#### **PR-2024-010078**

MINOR\_PLT-2025-00018 – PRELIMINARY/ FINAL PLAT

REQUEST: Create two new lots from three existing parcels.  
Dedication of right-of-way and granting of an access easement [7] and four utility easements

DRB Project Number: 2024-010078  
2101 Carlisle NE

**PROPOSED OVERALL
SITE PLAN**

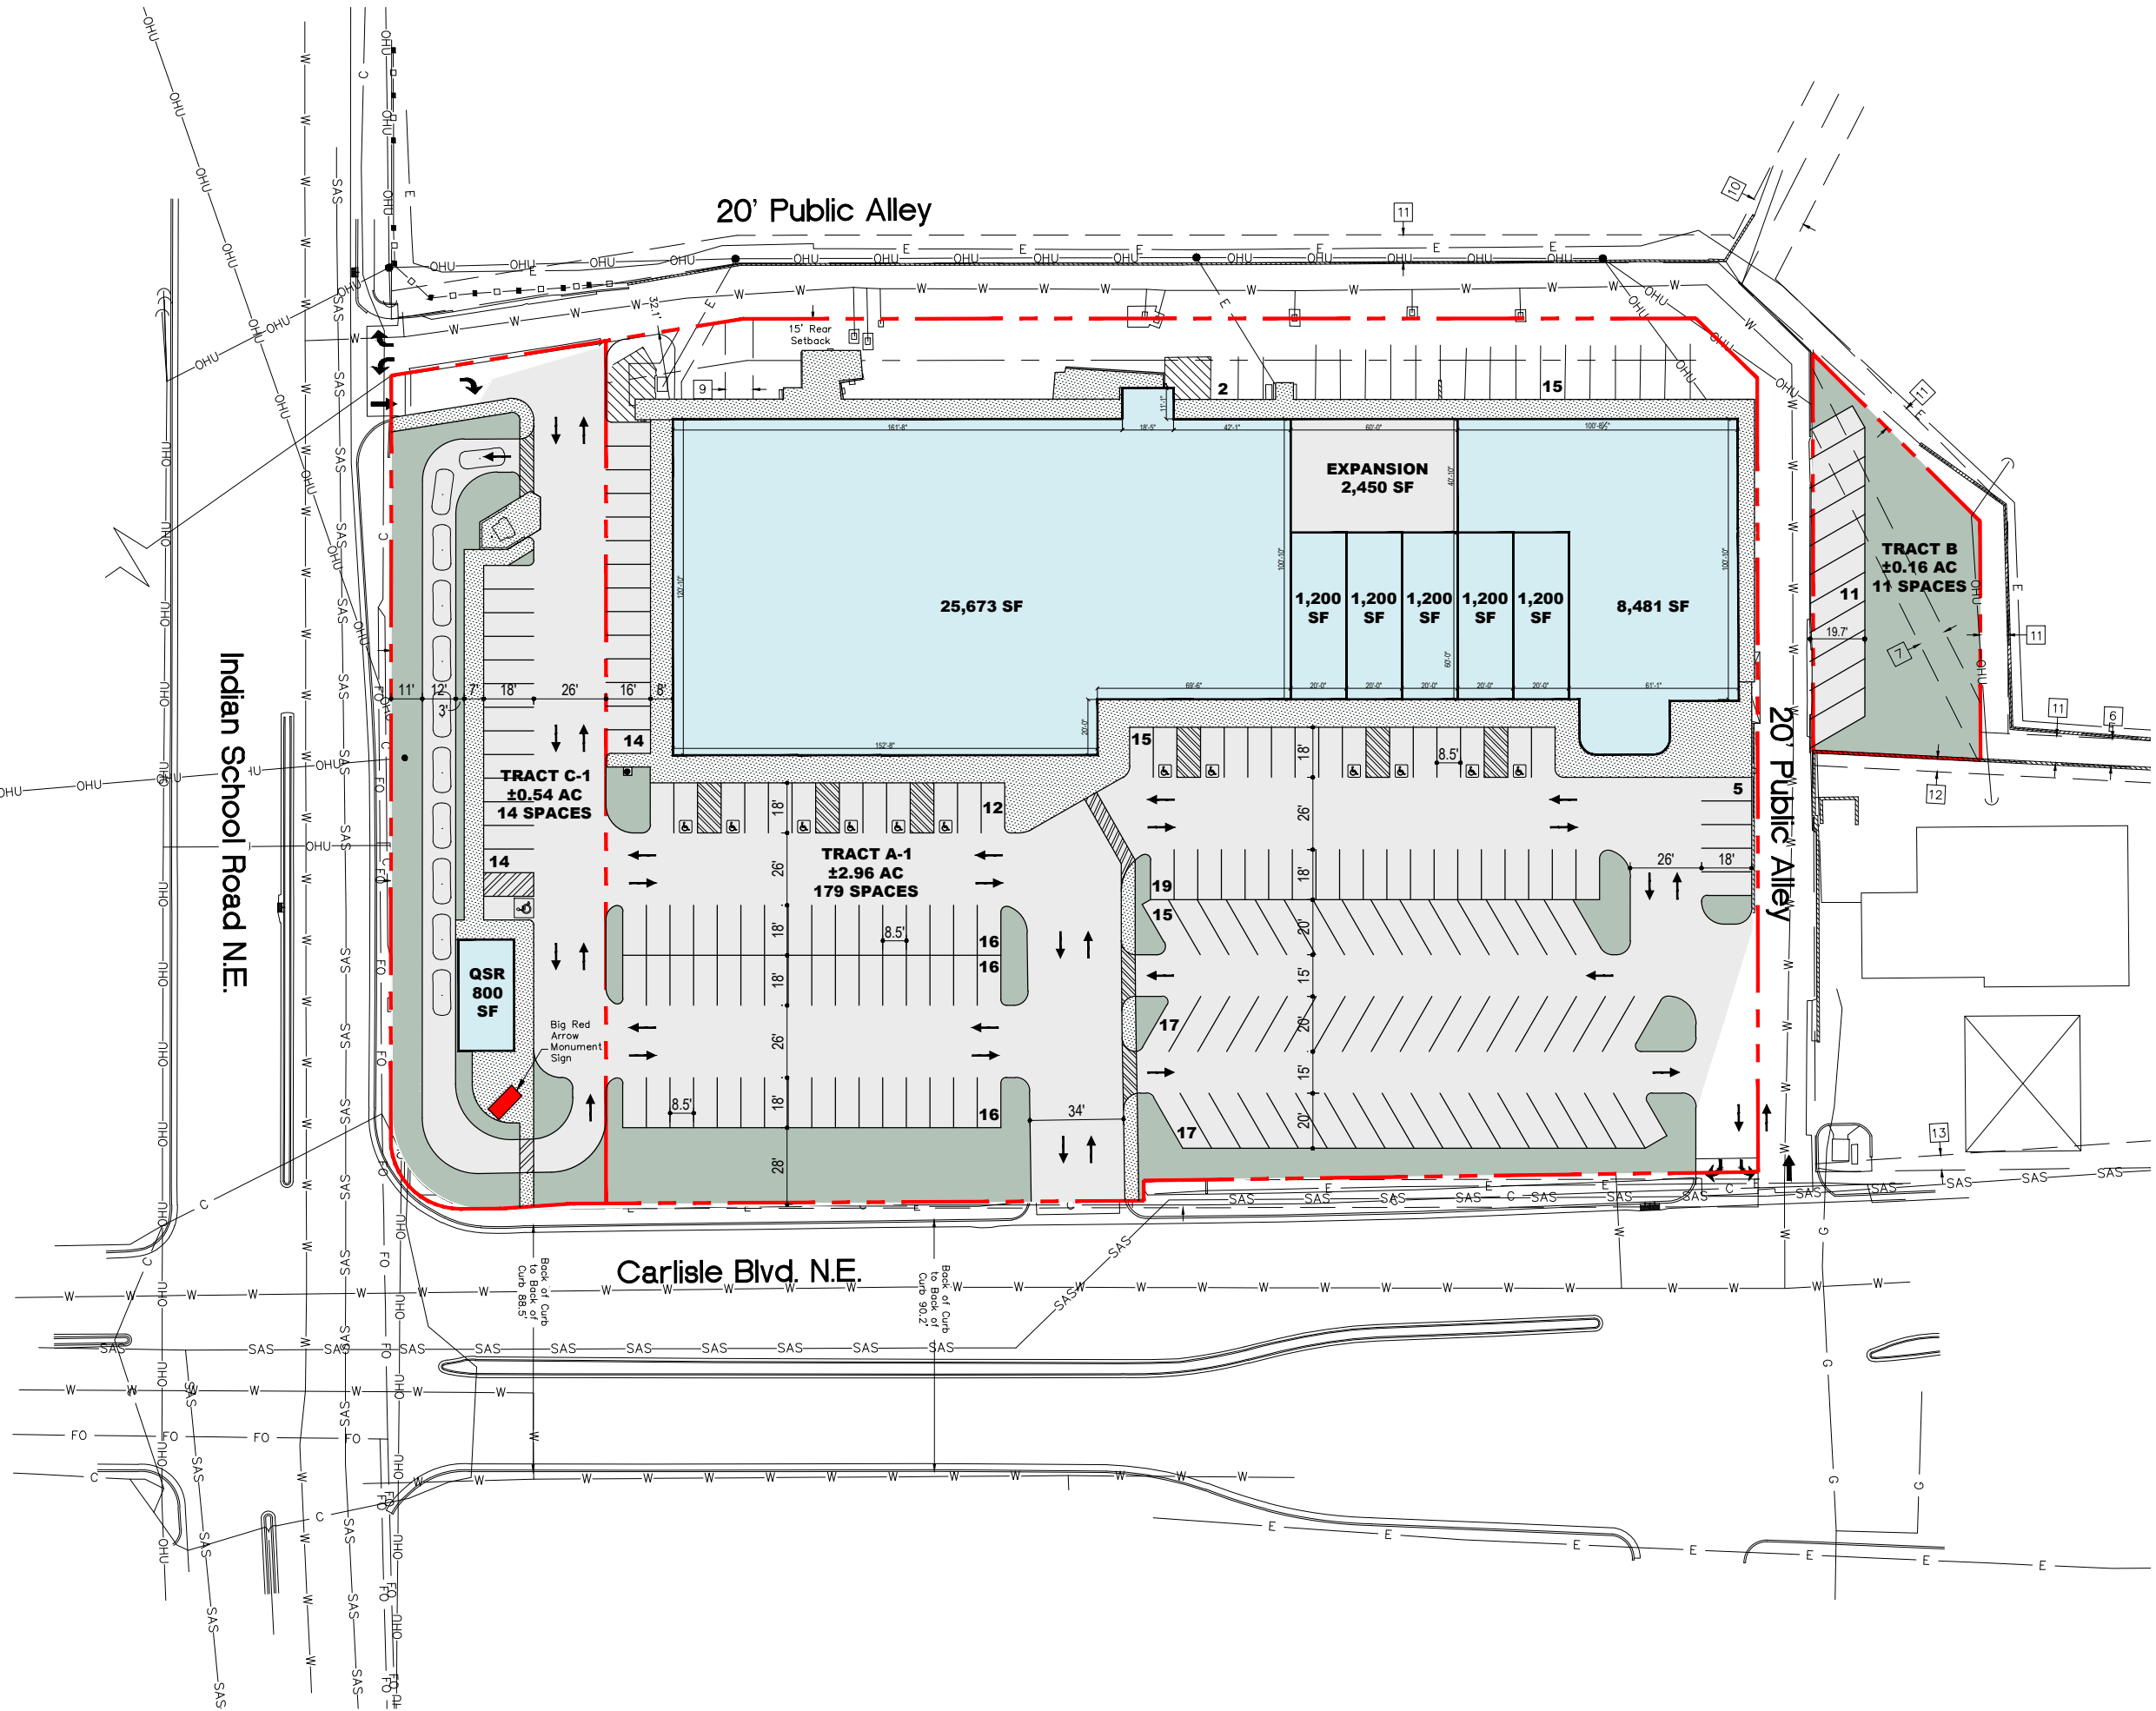
1. Carlisle and Indian School are both Minor Arterials and require 6' sidewalk with a 5' to 6' landscape buffer. Your infrastructure list shows widening along Carlisle from the alley to the site driveway. The rest of the site still does not provide dimensions of the sidewalk to show if they are adequate.
2. An approved TCL will be required prior to site plan or building permit. Also, a Traffic Scoping Form will be required to be submitted to determine if a TIS will be required.
